Please ask for: Ms Iqraa Malik
Email: iqraa.malik@terraquest.co.uk
Telephone: 0121 234 1390
Our Ref: F/2/22/HH
Your Ref:
Date: 7th March 2022

Application for Planning Permission for Works or Extension to a Dwelling

Development: Demolish existing single storey extension and detached garage.
New single storey side extension.

Location: 38 Nyewood Lane Bognor Regis PO21 2SJ

BLOCK PLAN 1:500

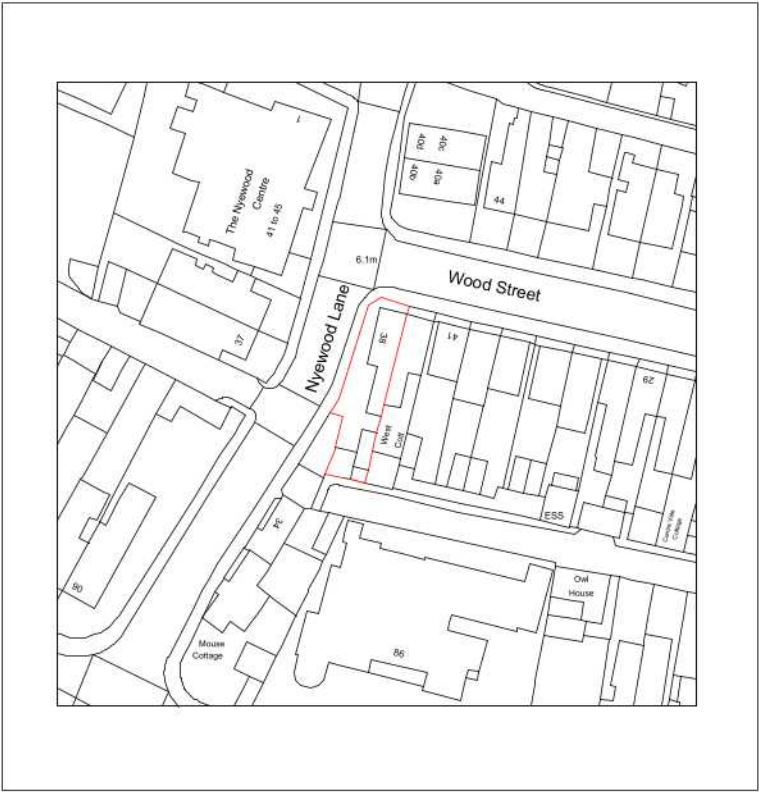
Dimensions: You are required to include dimensions on the block plan from the proposed extension(s) to ALL site boundaries. Please amend.
